Karuah Quarry Complex
ABN: 15 093 914 937
Hunter Quarries Pty Ltd
Andersite Road, Karuah NSW 2324

06 November 2023

RE: Karuah South Quarry (SSD-8795) – Amended Project Application
Hunter Quarries Submission – Review of Implications to Existing Quarry Operations

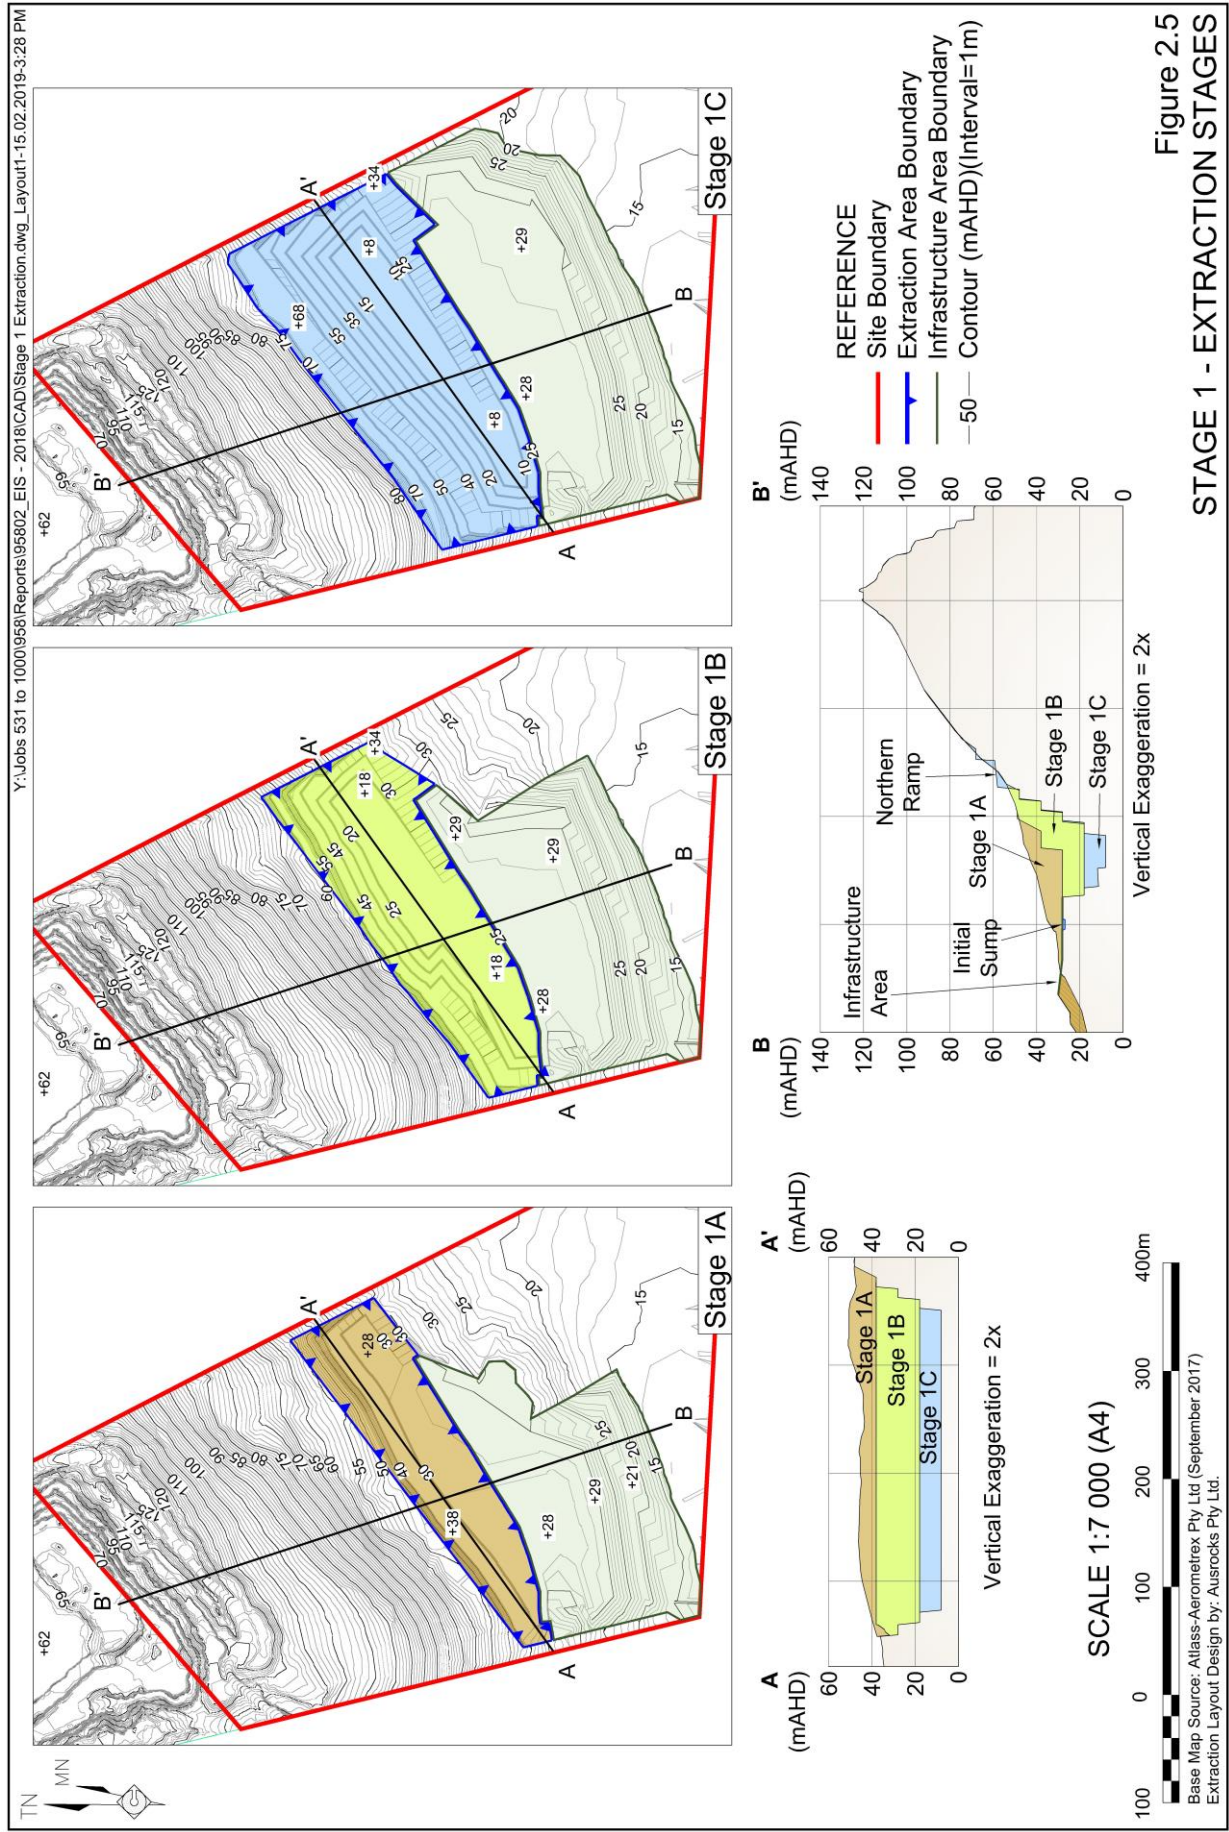
HQPL notes that the proposed KSQ provides a continuation of operations at the existing Karuah Hard Rock Quarry site by extracting the southern benches towards the M1 Pacific Motorway and residential receptors to the south along Mill Hill Close. This extraction will expose the remnant highwall between the Karuah Hard Rock Quarry & Karuah East Quarry as illustrated by the annotated cross-section provided by **Figure 1**.

This view of the final landform will have an adverse impact on the residual landscape of the Karuah East Quarry for both Mill Hill Close residential receptors and for vehicles along the M1 Pacific Motorway. The Department should consider substantially reducing this impact by requiring removal (or lowering) of the remnant highwall between the Karuah Hard Rock Quarry & Karuah East Quarry.

7.1. HQPL requests the Planning Secretary provide consideration of extraction sequencing to minimise adverse visual impacts by requiring the remnant highwall to be removed (or lowered) prior to the commencement of the KSQ project.
